**KIRKLEES METROPOLITAN COUNCIL
INVESTMENT & REGENERATION SERVICE**

DELEGATED DECISION TO DETERMINE PLANNING APPLICATIONS

Reference No:	2025/62/93528/E
Site Address:	80, Marsh Lane, Shepley, Huddersfield, HD8 8AS
Description:	Demolition of existing dwelling and annex and erection of 3 detached dwellings with associated access and parking (for 3 self build/custom build dwellings)
Recommending Officer:	Danielle Cooper

DECISION – Refused

## HOUSE TYPE 01 GA PLANS AND ELEVATIONS 1:100 @ A1

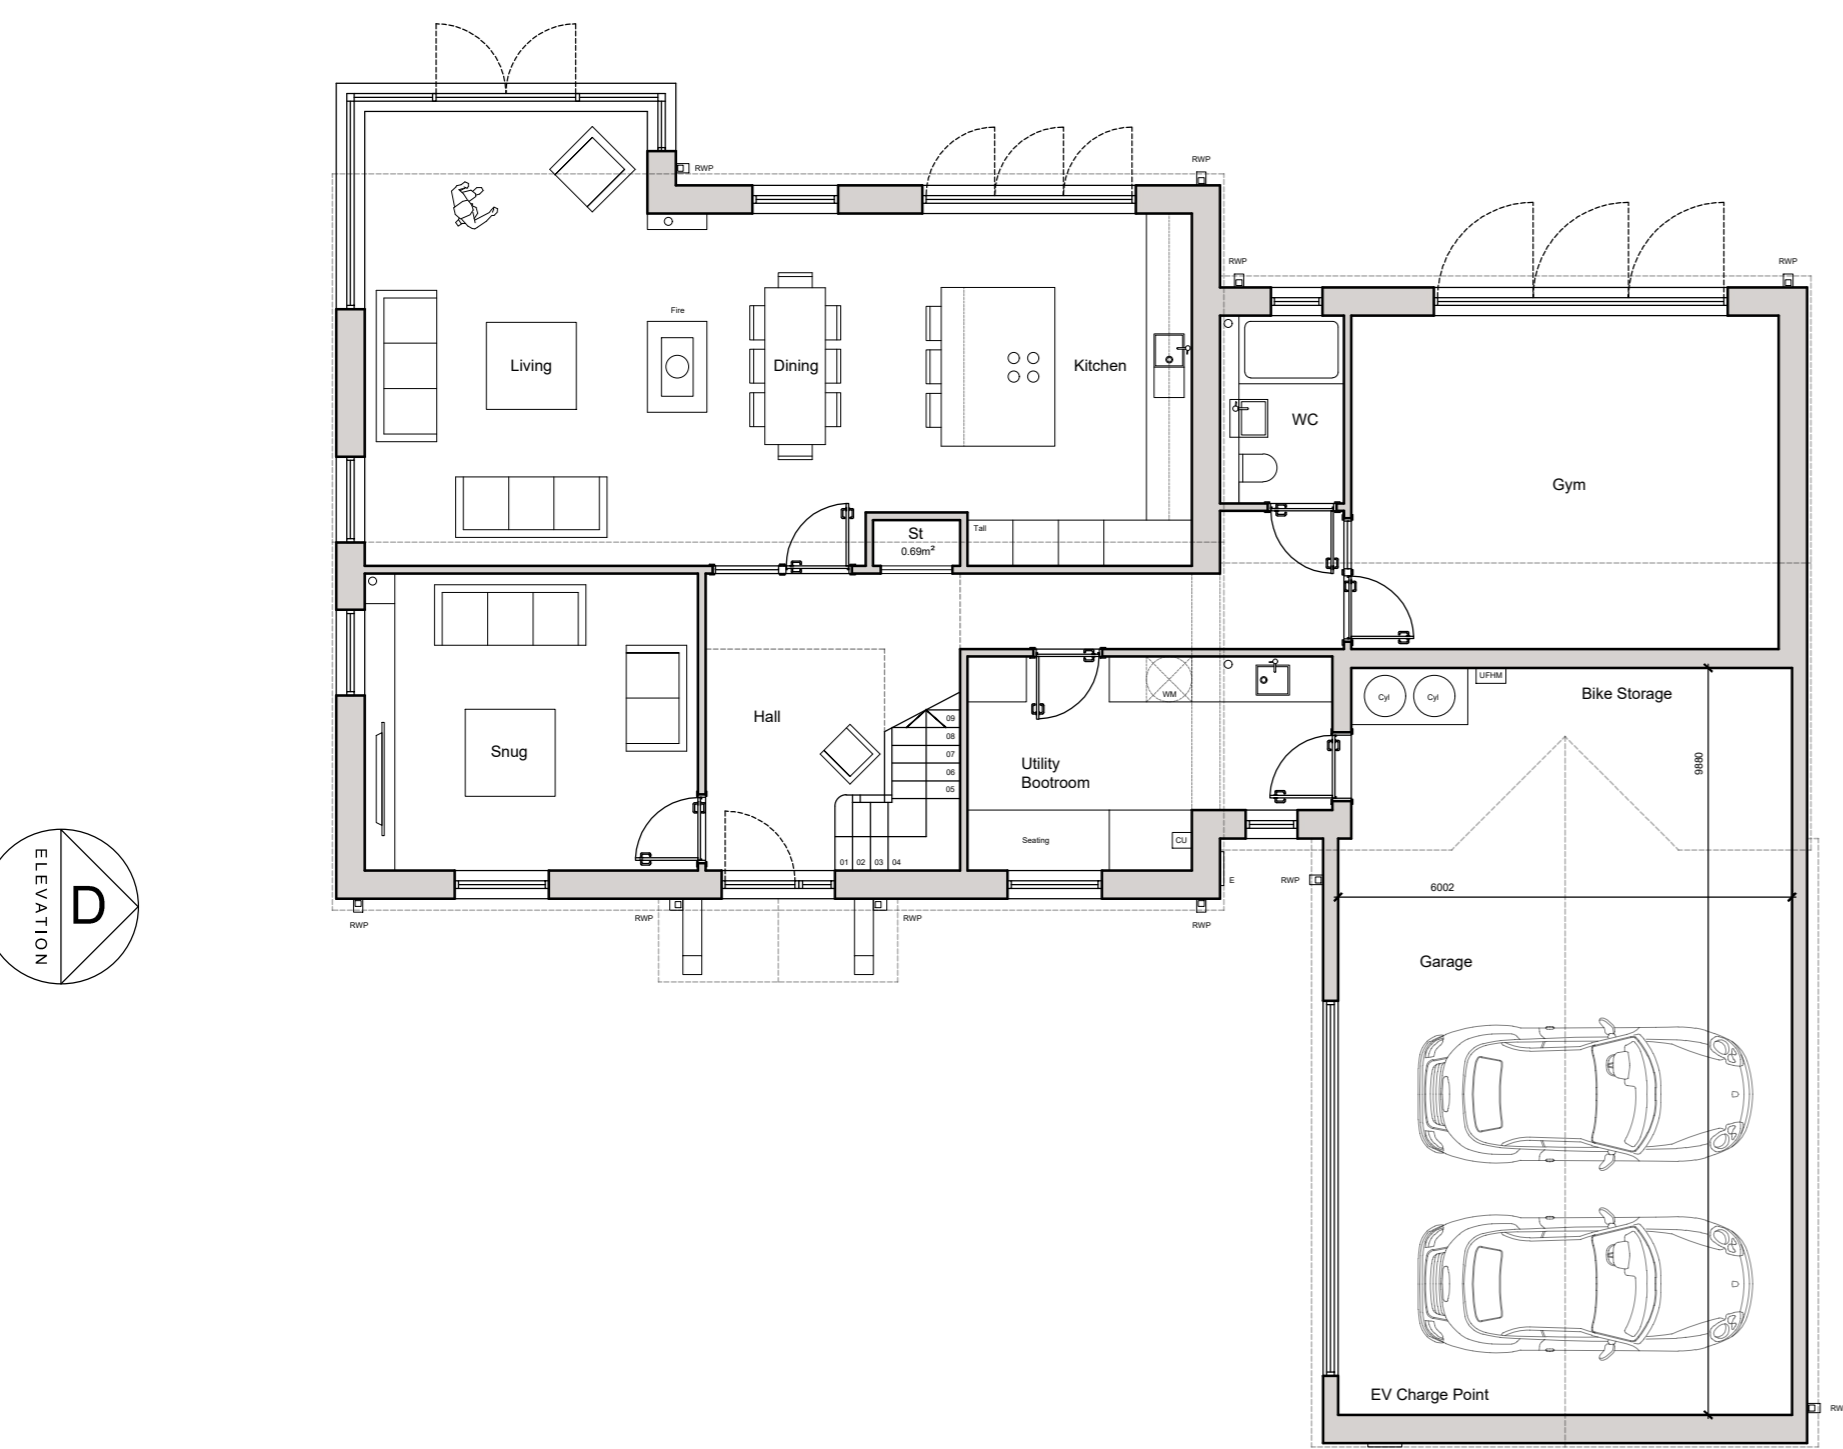
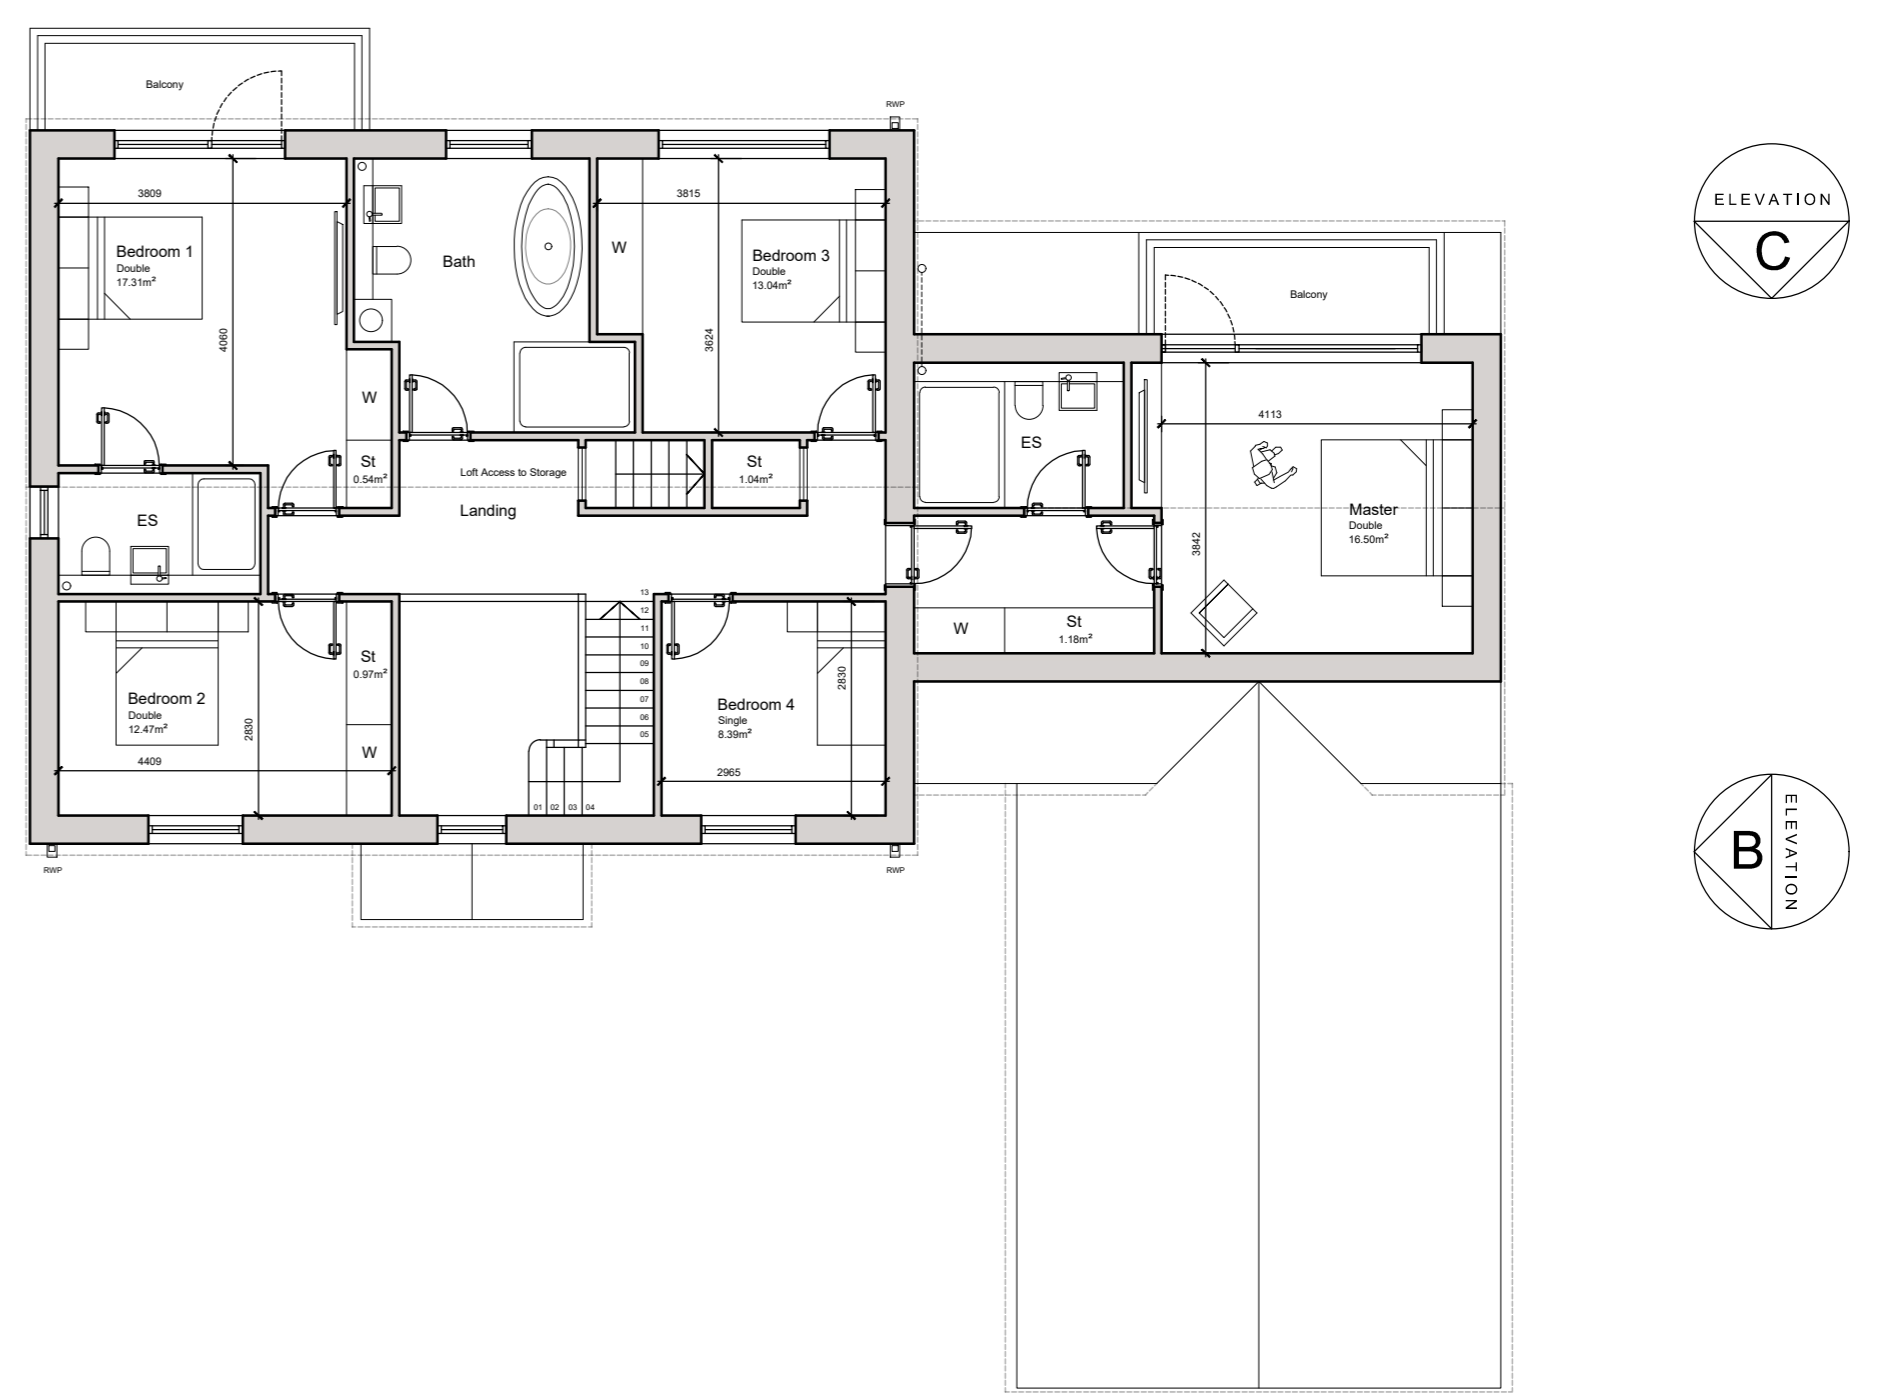
Plot 1 is positioned approximately 1.5 m from the shared boundary with No. 82 and sits adjacent to the end of No. 82's rear garden. As the proposed dwelling is located only at the far end of the garden, and No. 82 retains a substantial amount of usable private amenity space that is well separated from the new buildings, the development is not considered to result in an overbearing impact. Furthermore, due to the relative orientation between Plot 1 and No. 82, any overshadowing would be limited to the early morning and would be minor in nature, resulting in no unacceptable loss of light.

HOUSE TYPE 02 GA PLANS AND ELEVATIONS 1:100 @ A1

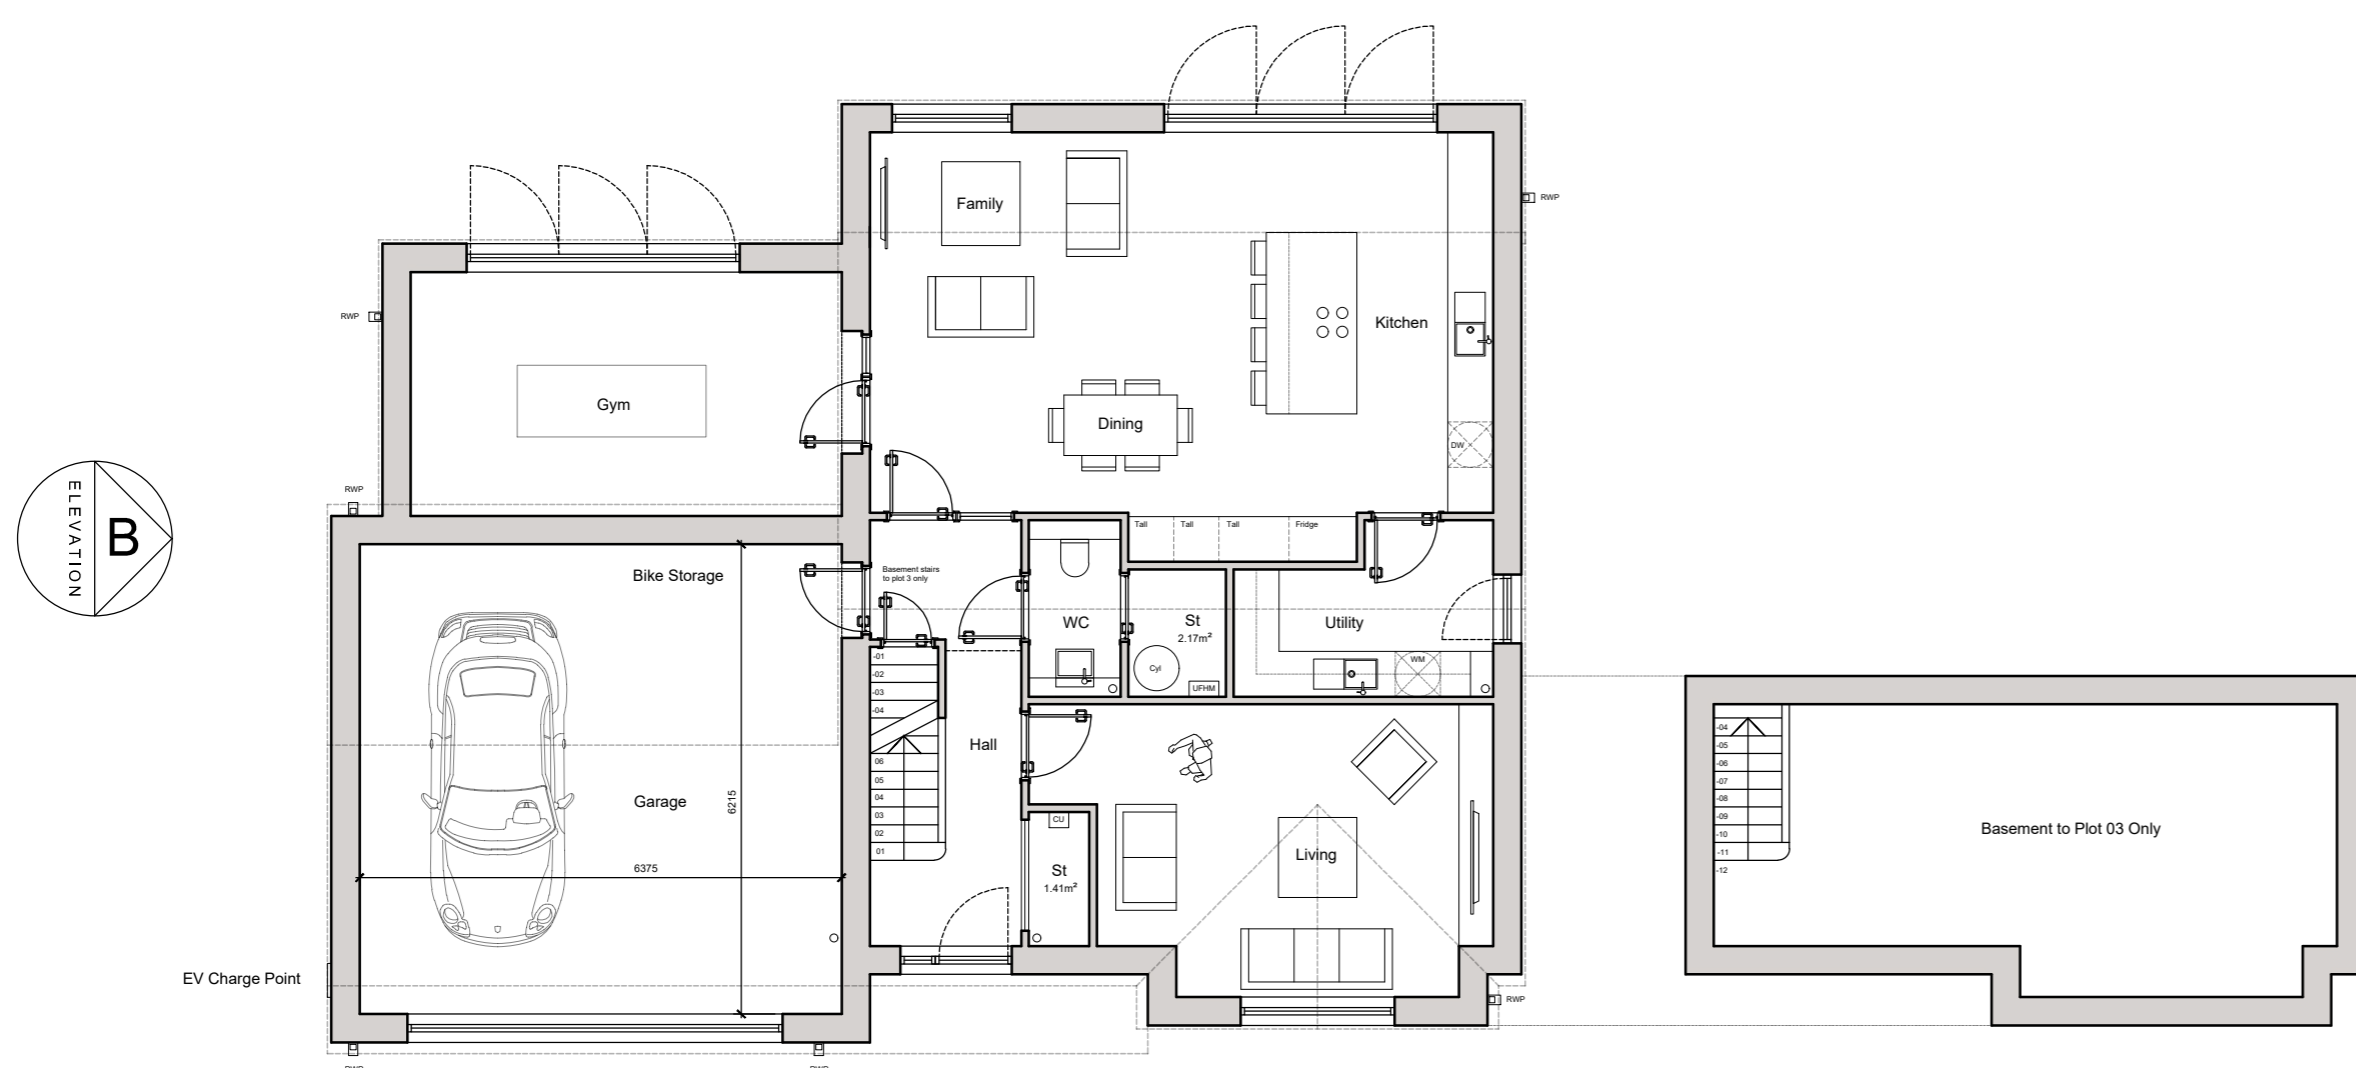
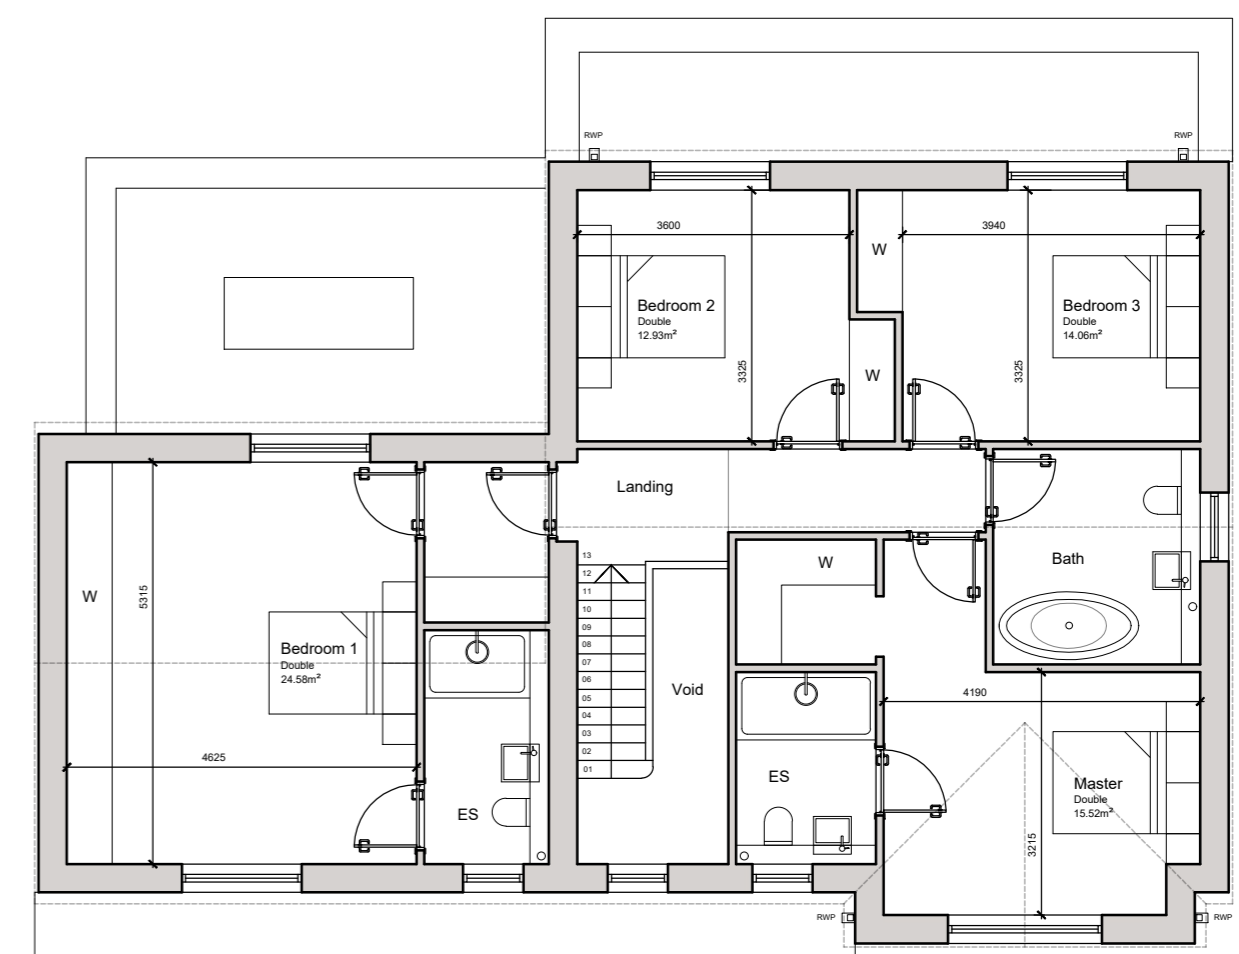
As previously outlined, the prevailing character along Marsh Lane is defined by dwellings that present their principal elevation to the street. In contrast, Plot 3 would not front Marsh Lane, with its side elevation addressing the street. This arrangement disrupts the established pattern of principal elevations facing the highway and fails to respect the existing urban grain. To have a side wall facing onto the street would act to diminish the established street pattern and character of the area, further adding to the adverse affect of the development on the character of the area.

Plot 2 includes front-facing fenestrations that looks toward the rear garden of No. 82, with a separation distance of 12.3 m. While a degree of perceived overlooking may arise, this relationship is consistent with other properties in the surrounding area, and the separation distance remains acceptable. On balance, the level of overlooking is considered acceptable and would not result in a significant harmful loss of privacy to No. 82 sufficient to justify refusal.

Plot 2 includes rear-facing fenestrations that looks toward the rear garden of No. 78, with a separation distance of 10.5 m. While a degree of perceived overlooking may arise, this relationship is consistent with other properties in the surrounding area, and the separation distance remains generous. On balance, the level of overlooking is considered acceptable and would not result in a harmful loss of privacy to No. 78 sufficient to justify refusal.
